From: Liz Rogers [REDACTED]
Sent: 28 January 2019 14:36
To: Planning.Responses
Subject: RE: Planning Consultation on: EG/7/19/PL

App No: EG/7/19/PL

Address: 26 Downview Road Barnham PO22 0EG

Proposal: Demolition of existing detached dwelling & garage & erection of 1 No. dwelling with car port.

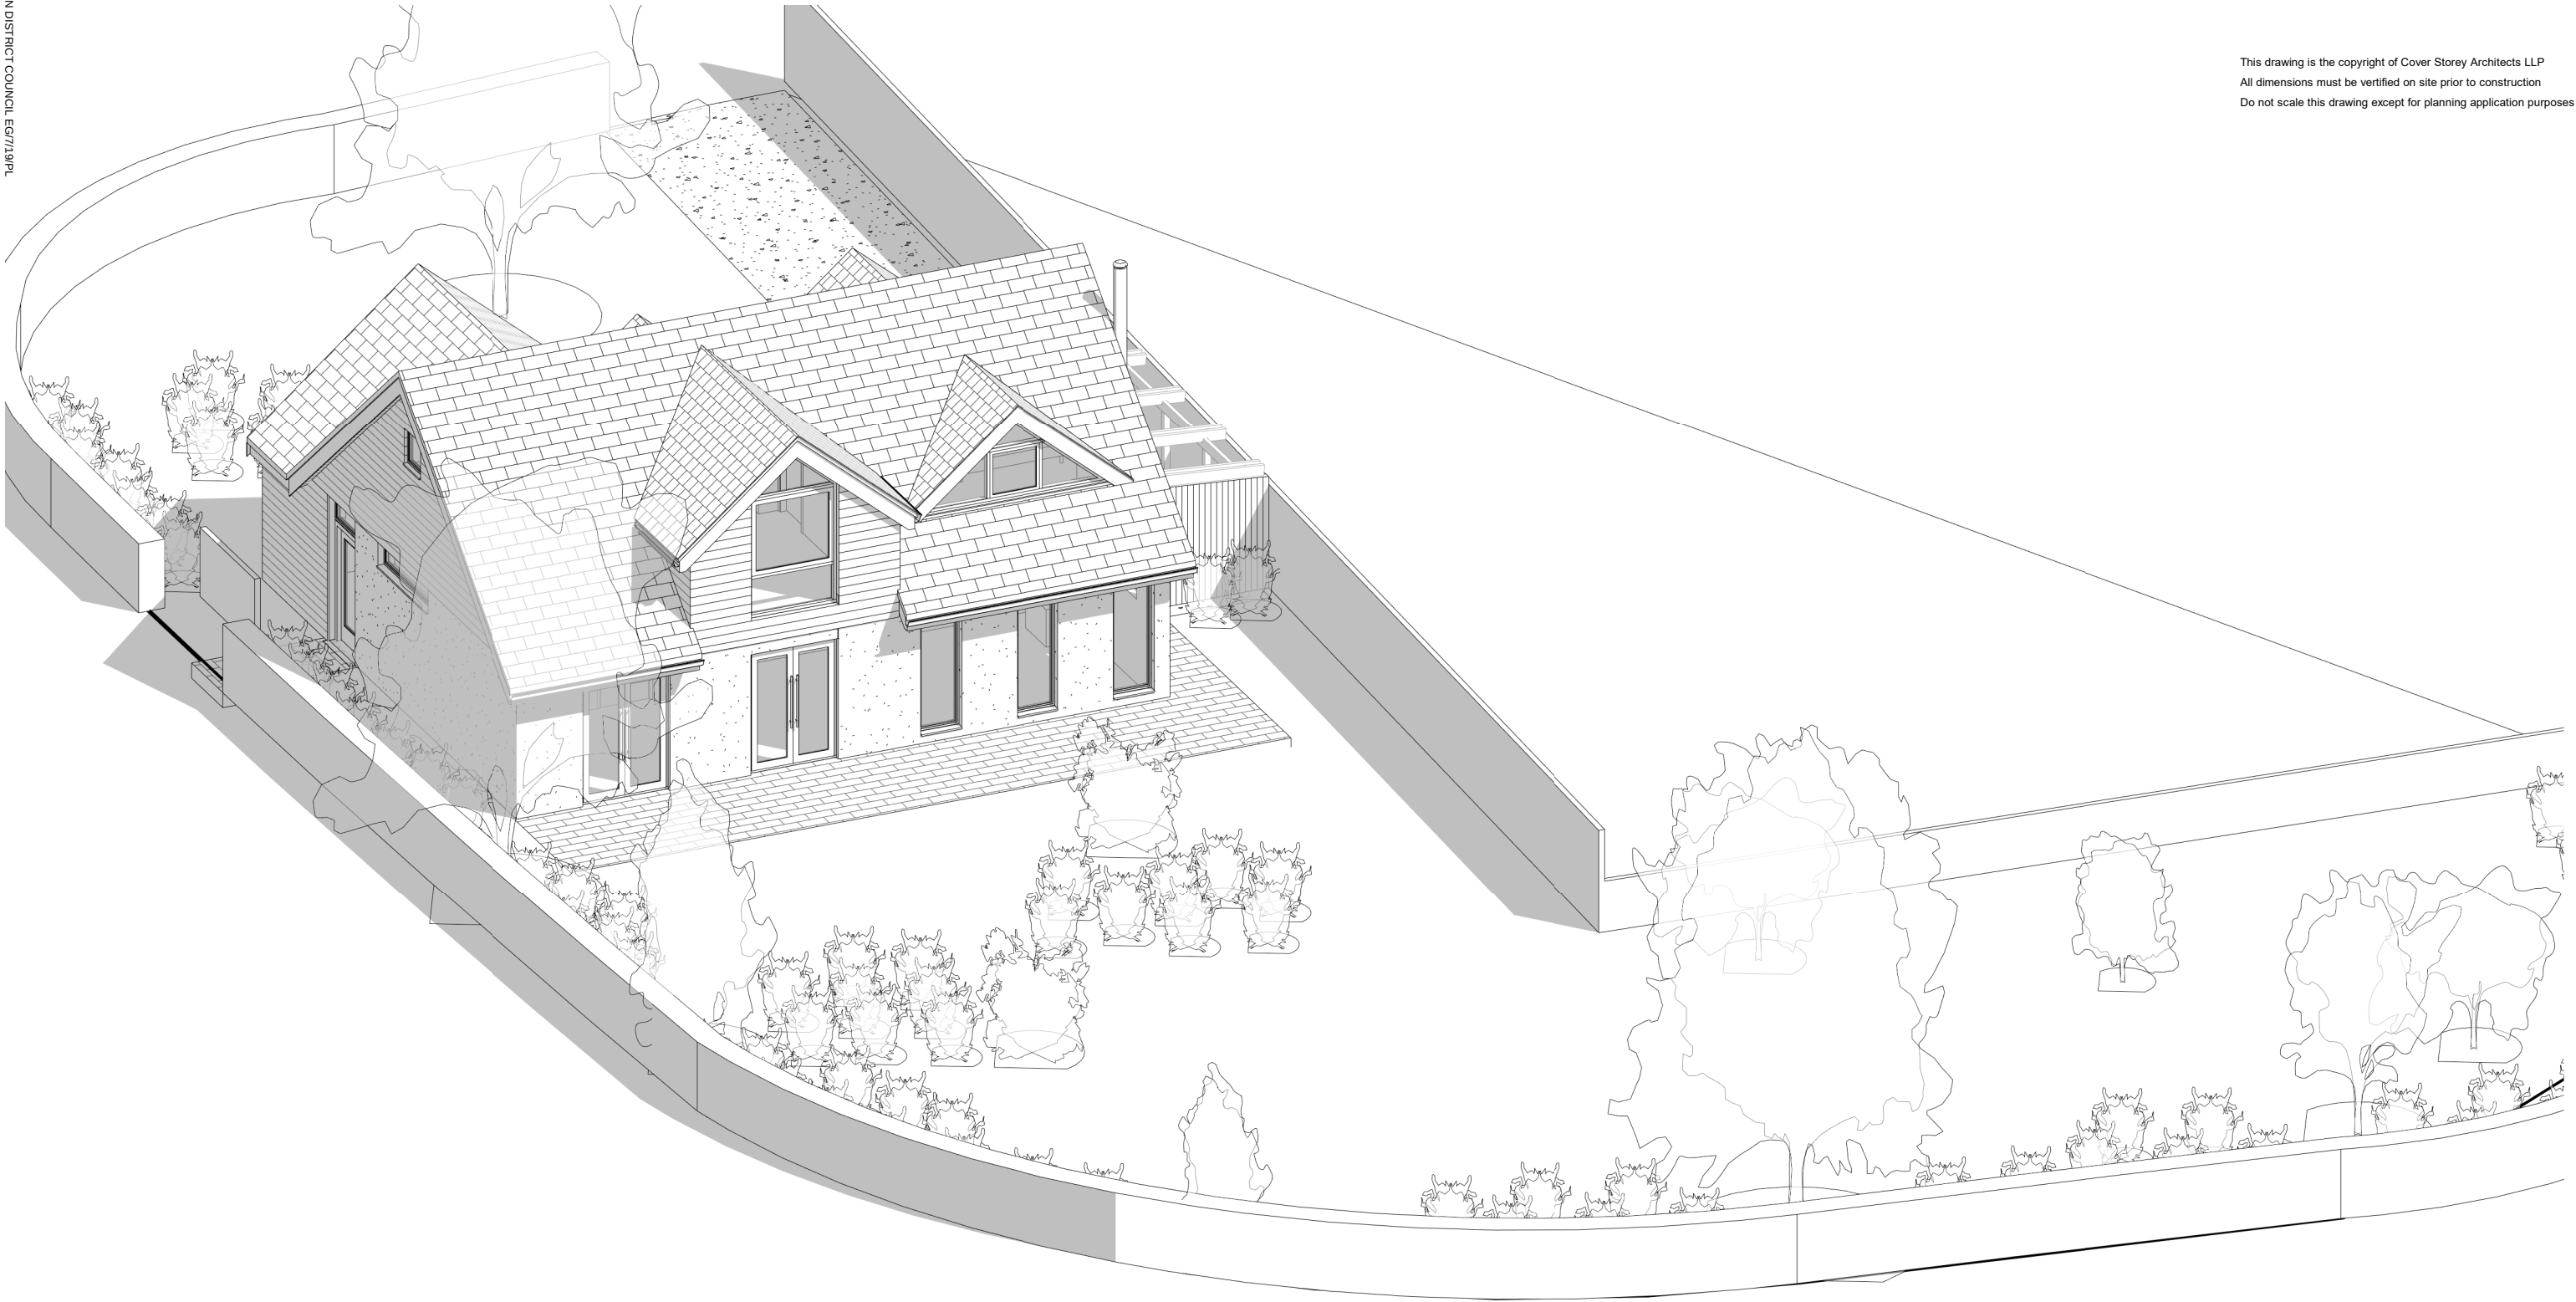
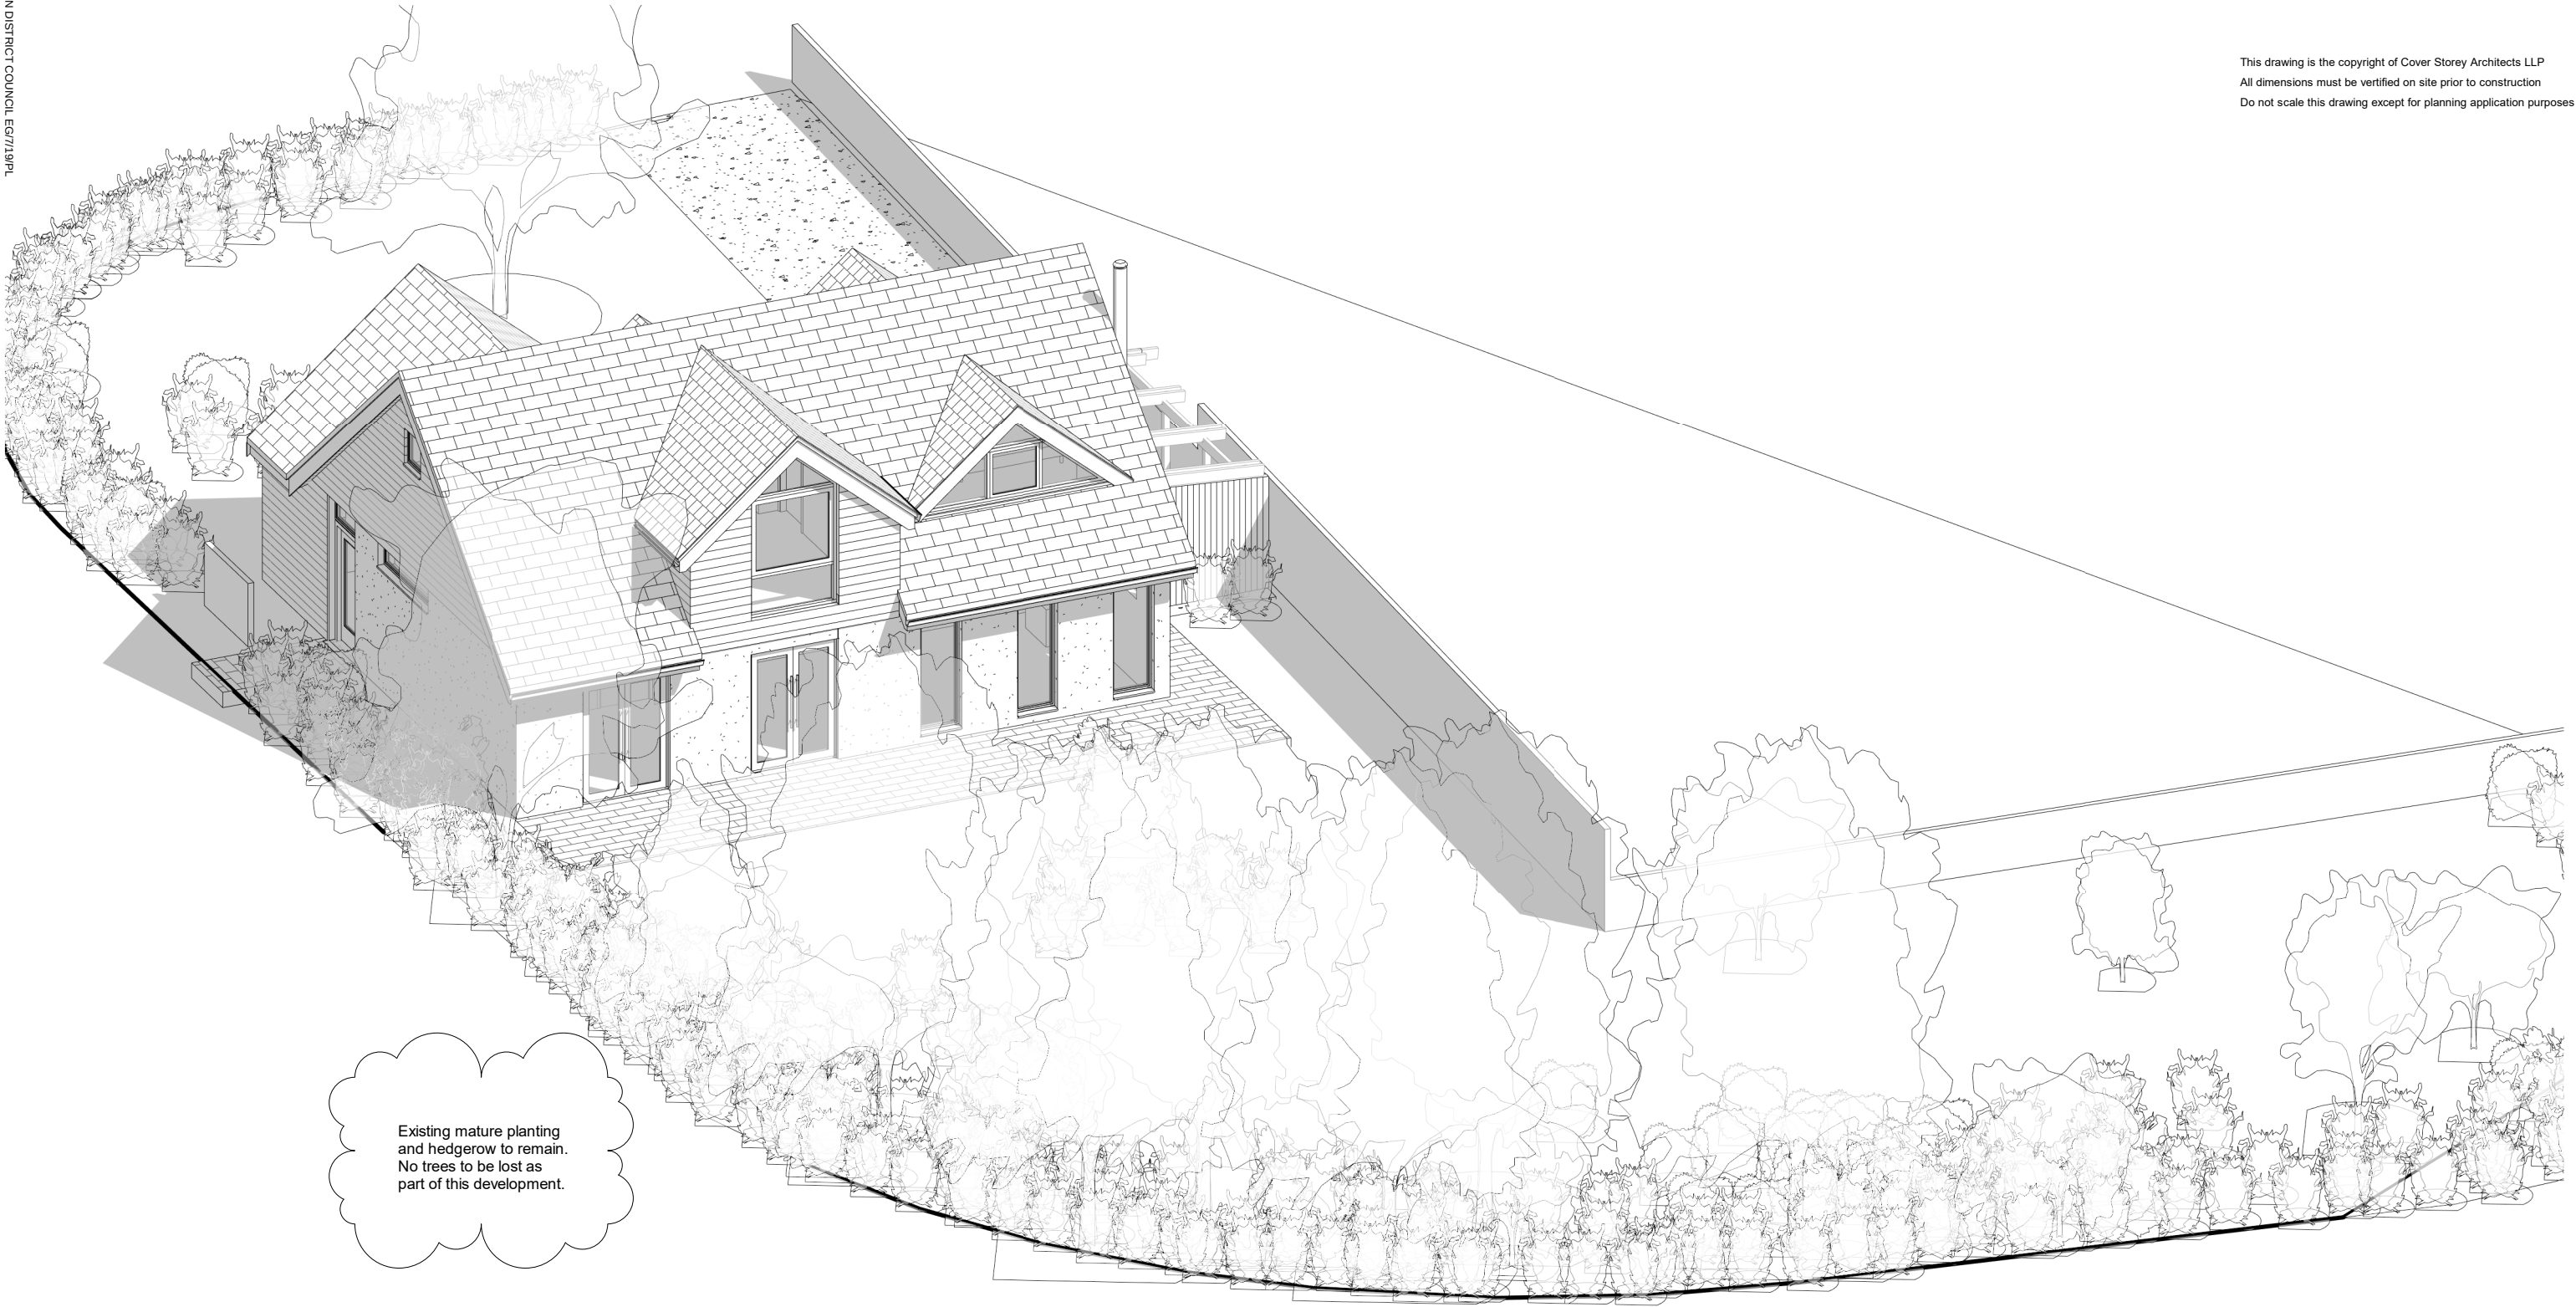
The hedgerows on site are used by bats for commuting and foraging and will need to be retained and enhanced for bats. This will include having a buffer strip around the hedgerows.
